From: David Harman (Allan B Matthews) [REDACTED]
Sent: 21 February 2018 11:54
To: Daun Johnson
Subject: FW: WA/12/18/PL - Shell Fontwell

From: Anita Gardner [<mailto:Anita.Gardner@arun.gov.uk>]
Sent: Wednesday, 21 February, 2018 11:49
To: 'David Harman (Allan B Matthews)'
Subject: RE: WA/12/18/PL - Shell Fontwell

TITLE : ELECTRIC CHARGING POINT

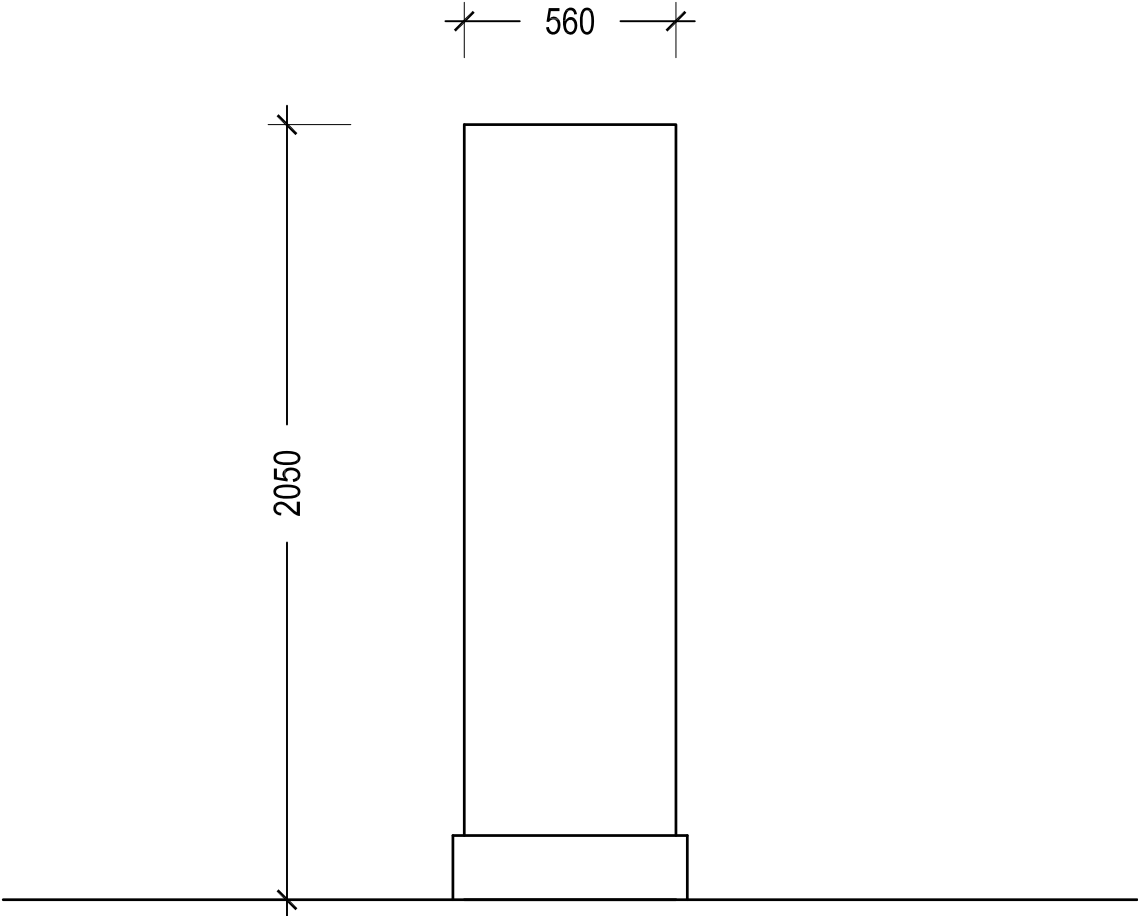
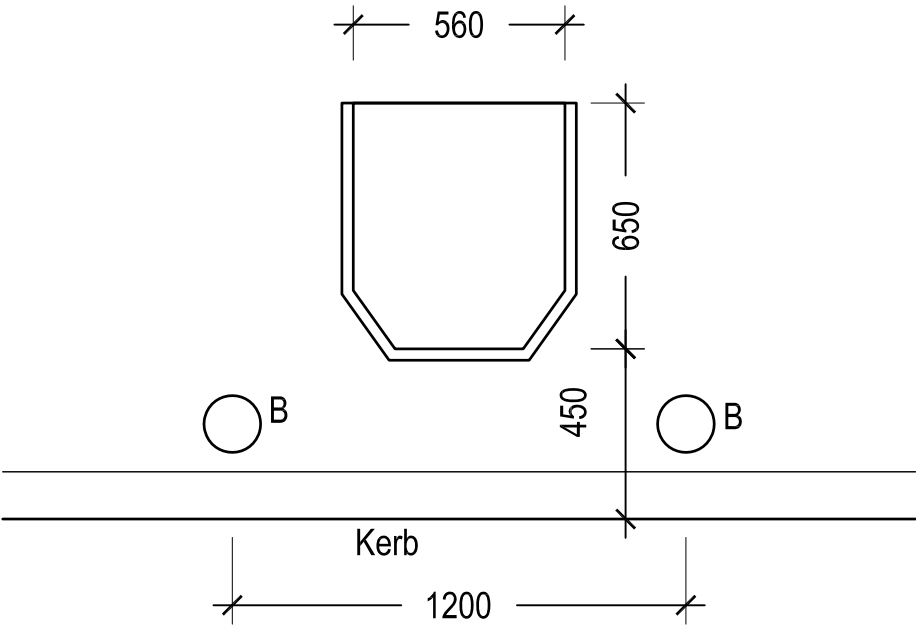
- (i) I confirm the condensers are being replaced. Full details not available at this time.
- (ii) See attached section through the electric charging points.
- (iii) See attached Local Validation Checklist
- (iv) See attached Bio Diversity Checklist
